1. Do you have any comments on our proposed route from the Brockworth bypass to Shab Hill Junction?

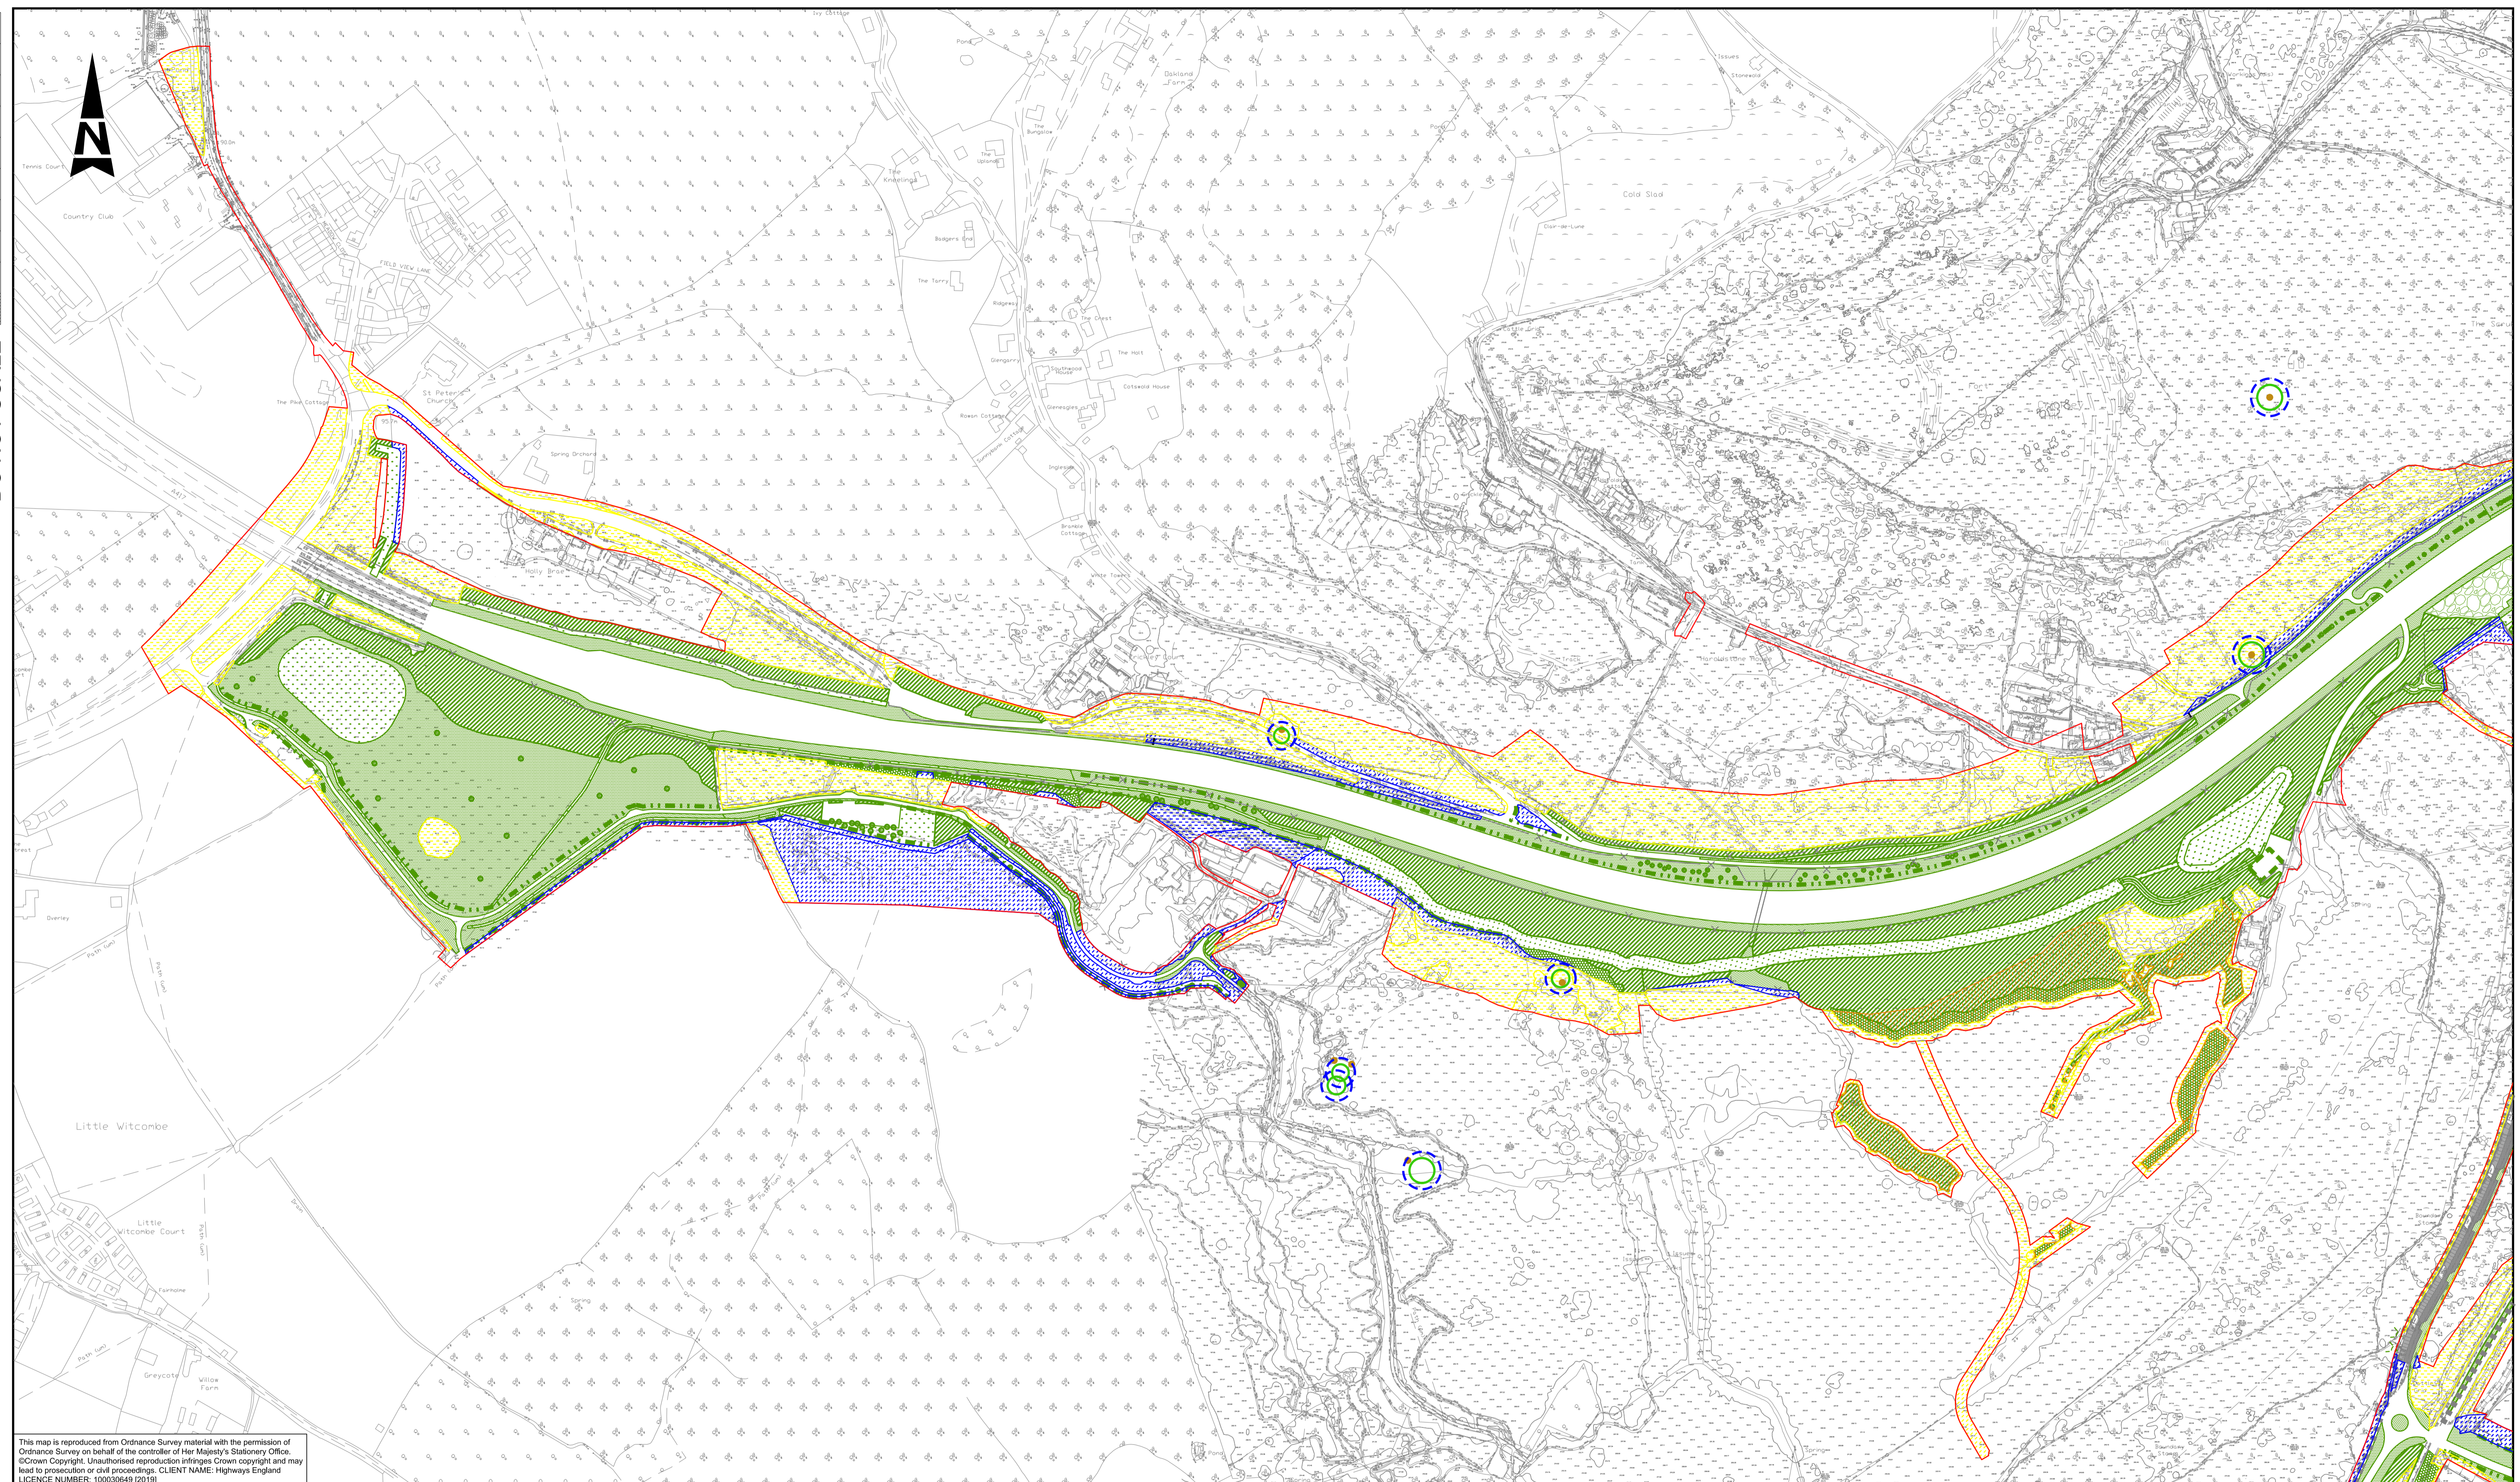
There is a triangle of trees at grid ref SO 934 159 alongside the current road, opposite the Air Balloon which contains three bowl barrows, a mix of predominantly beech, ash, oak trees and some carved stonework was observed on the ground there. Option 30 proposal impacts the woodland and heritage site.

According to the PEIR, the plan is to remove the apex of the triangle and place a retaining wall there alongside the new road. The plans show a thinning of the trees at the sites of the bowl barrows leaving one strip alongside the Gloucestershire Way Footpath.

This woodland and heritage site, through which the Gloucestershire Way runs, is a treasured part of the walking environment, contributing to the enjoyment of the countryside. The trees should be retained with thinning kept to a minimum, especially in the beech grove section which contribute to the areas of beech wood renowned in the Cotswolds.
